**PROJECT:** Communities Plus, Eden St, Arncliffe  
**RE:** SDRP SESSION 62 – 09.09.2020 (first review)

**PROJECT:** Communities Plus, Eden St, Arncliffe  
**RE:** SDRP SESSION 65 – 21.10.2020 (second review)

PROJECT: Communities Plus, Eden St, Arncliffe  
RE: SDRP SESSION 73 – 31.03.2021 (third review)

3D-1 SOLAR COMPLIANCE FOR COMMUNAL OPEN SPACE

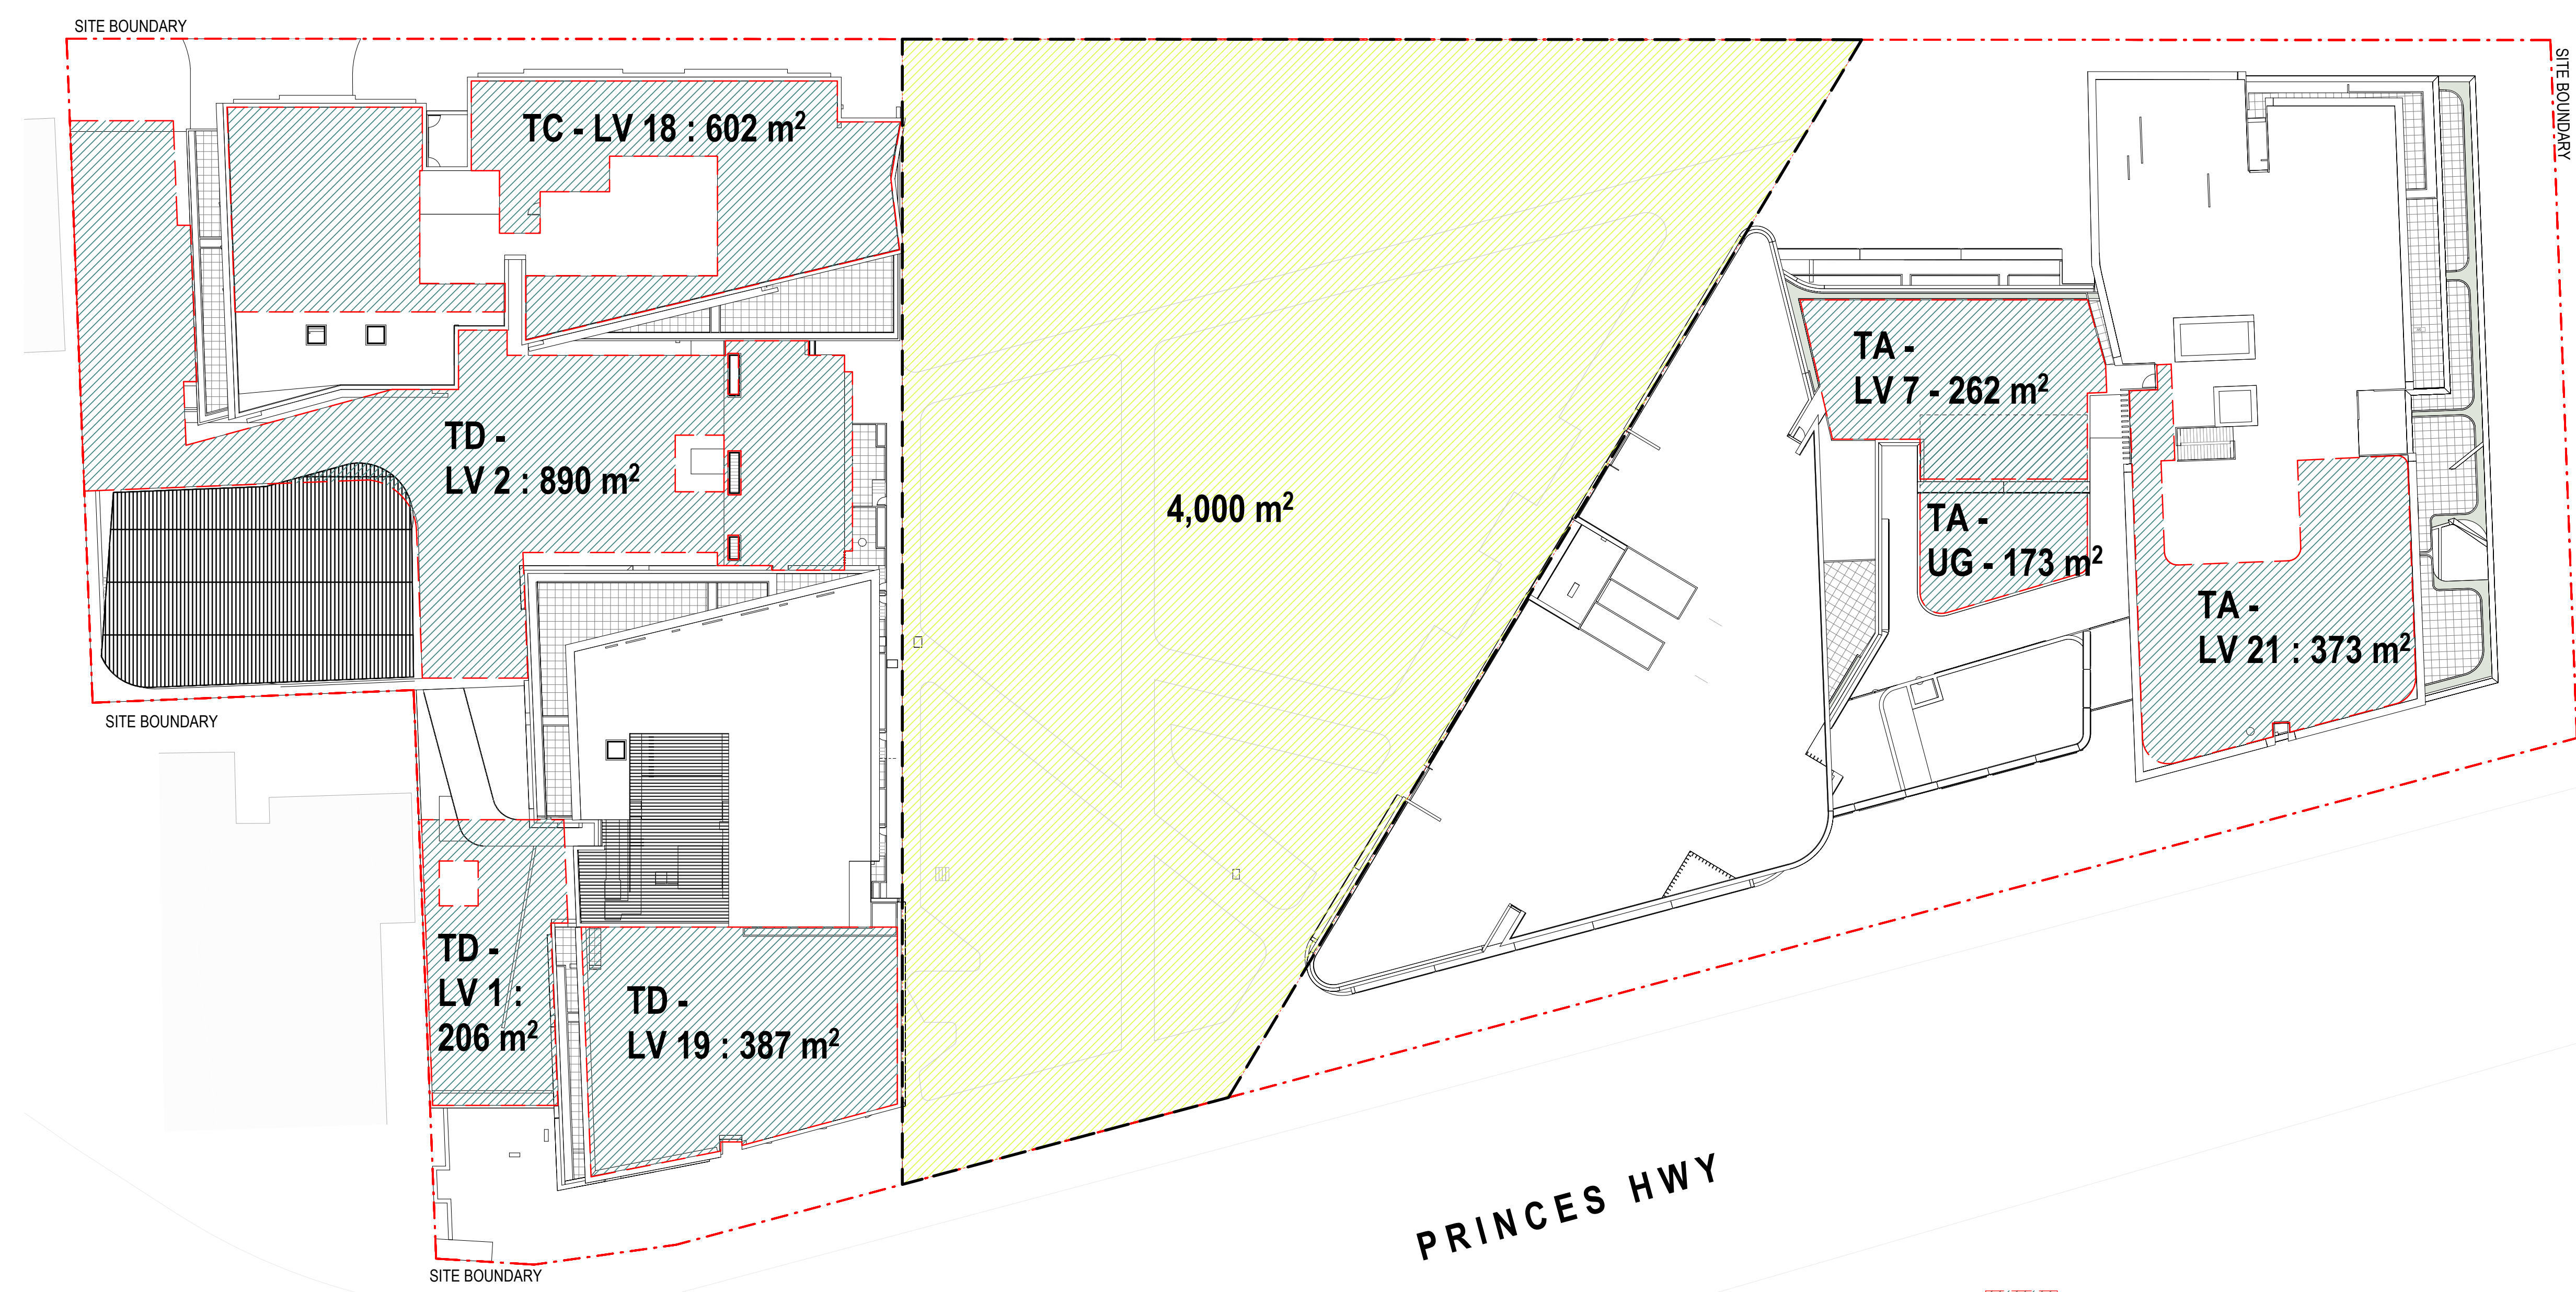
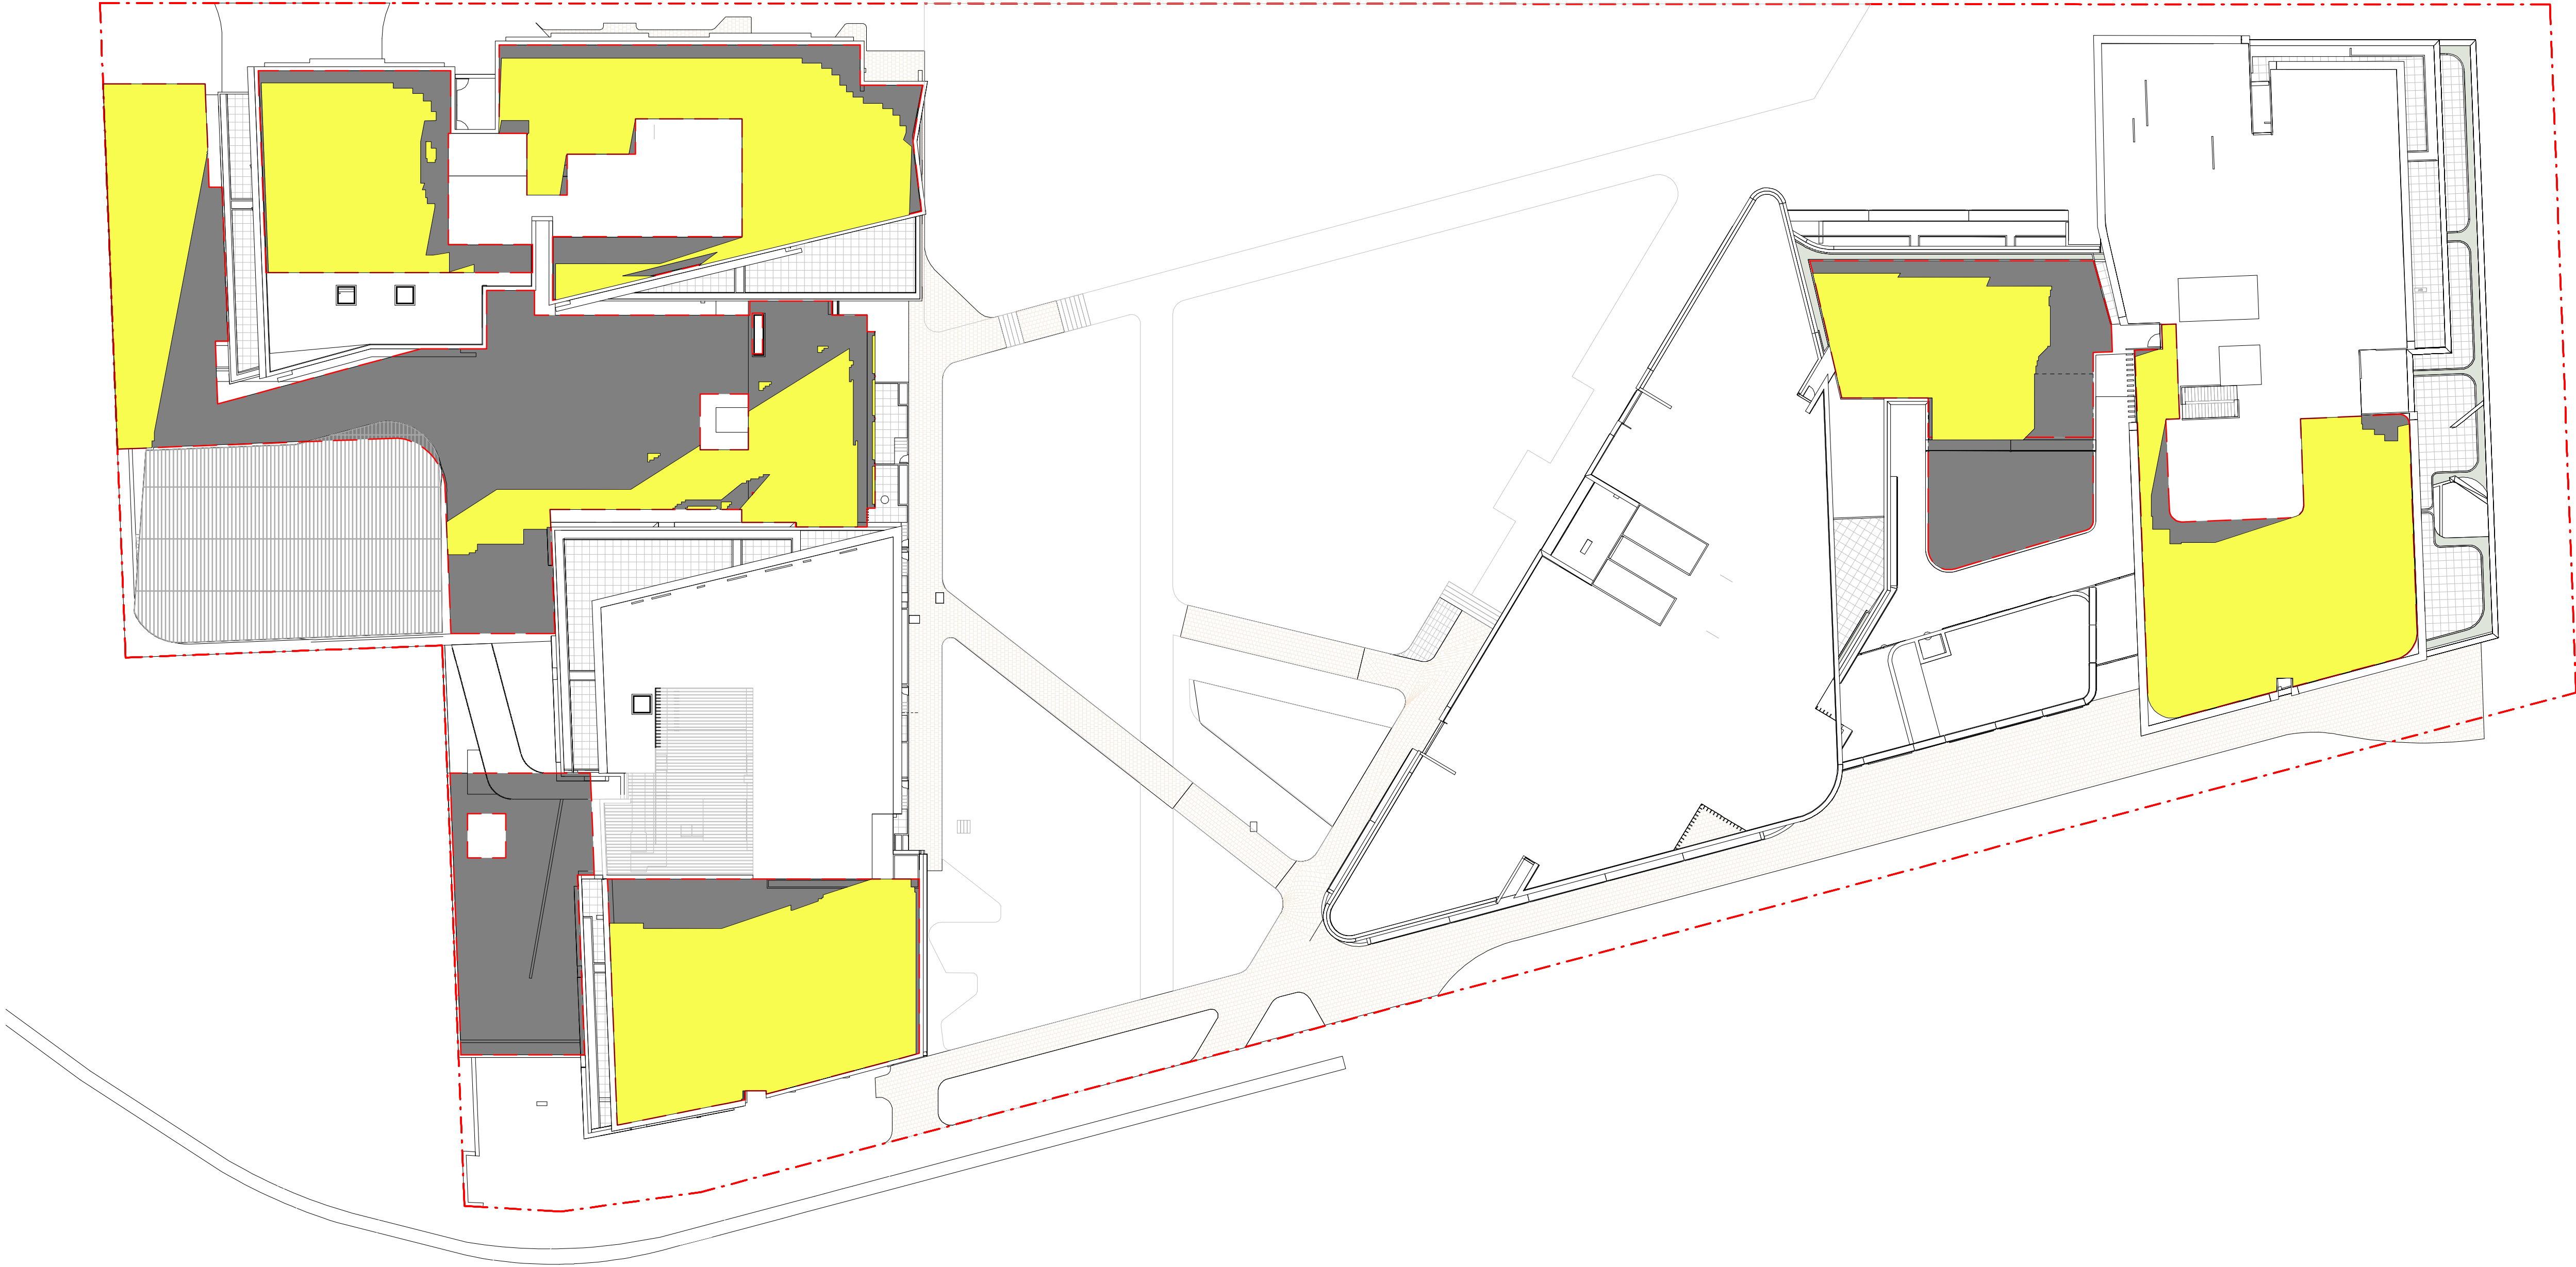
The distribution of communal open space for residents throughout the development is encouraging and use of rooftops will ensure high amenity, year round solar access and privacy. The location of the Social and Affordable Housing COS at podium level in an overshadowed location is not supported – if it cannot be moved to the rooftop due to LAHC policy, an alternative location at ground or podium level must be allocated.

1 PARK AREA SOLAR - OVERALL
1 : 500

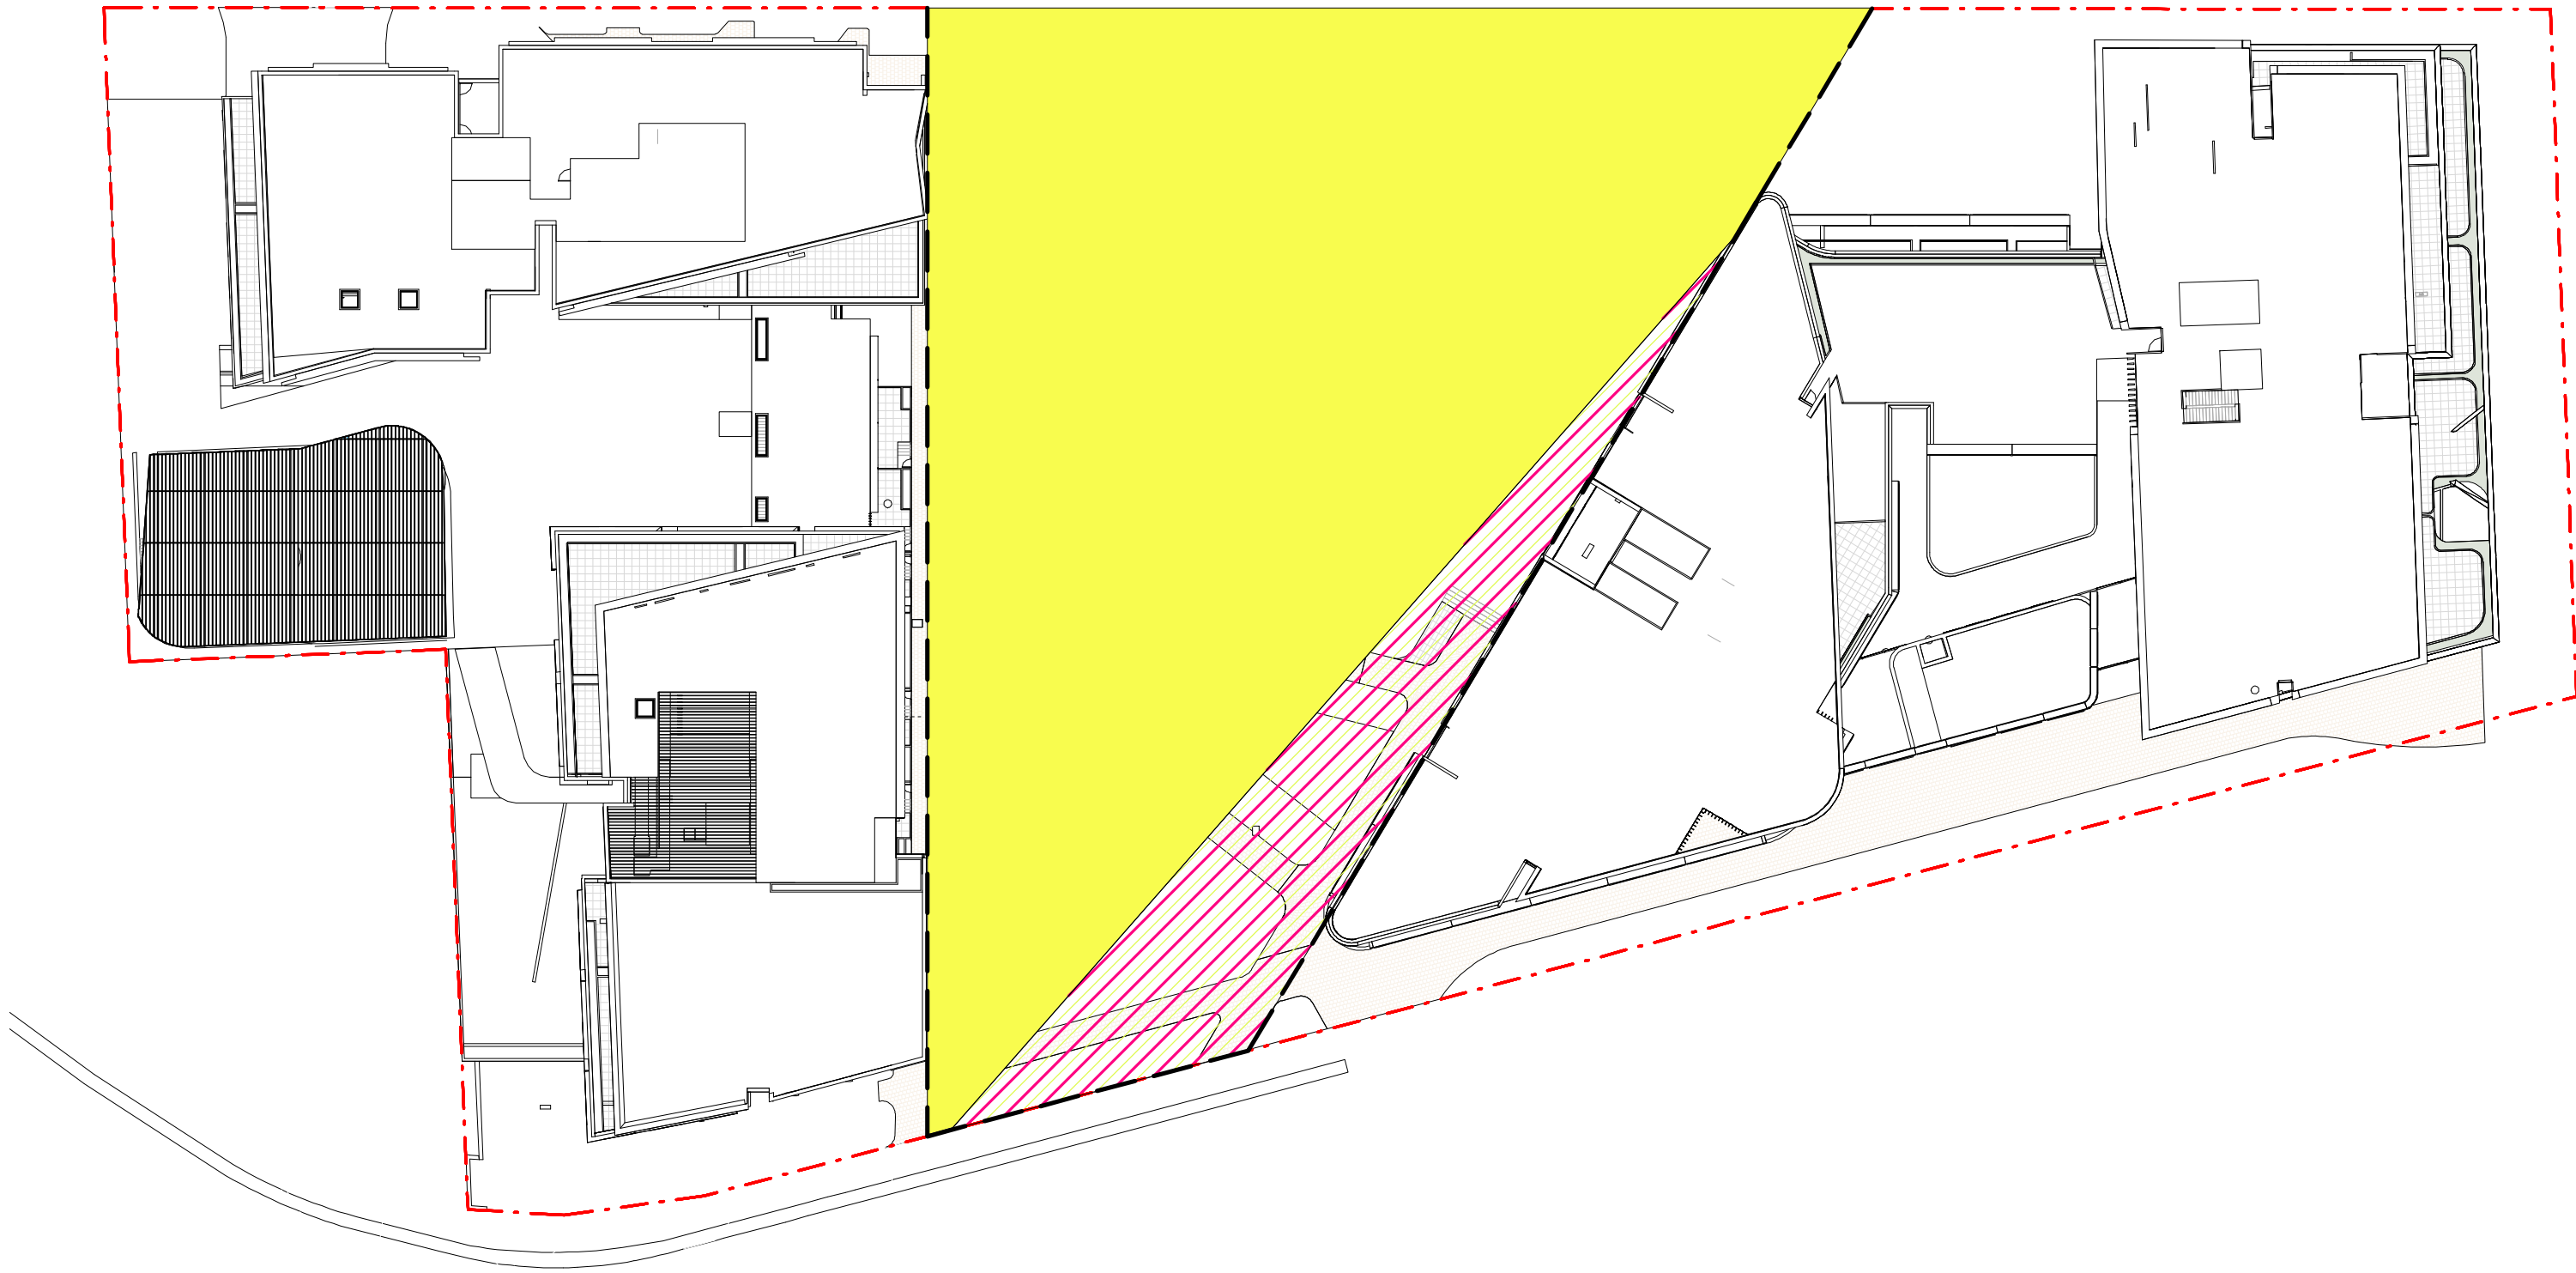
The 4000 square metre park is now entirely open to sky and excludes the northern through site link in the area calculation. This consolidated publicly accessible open space is supported and should remain through design development.
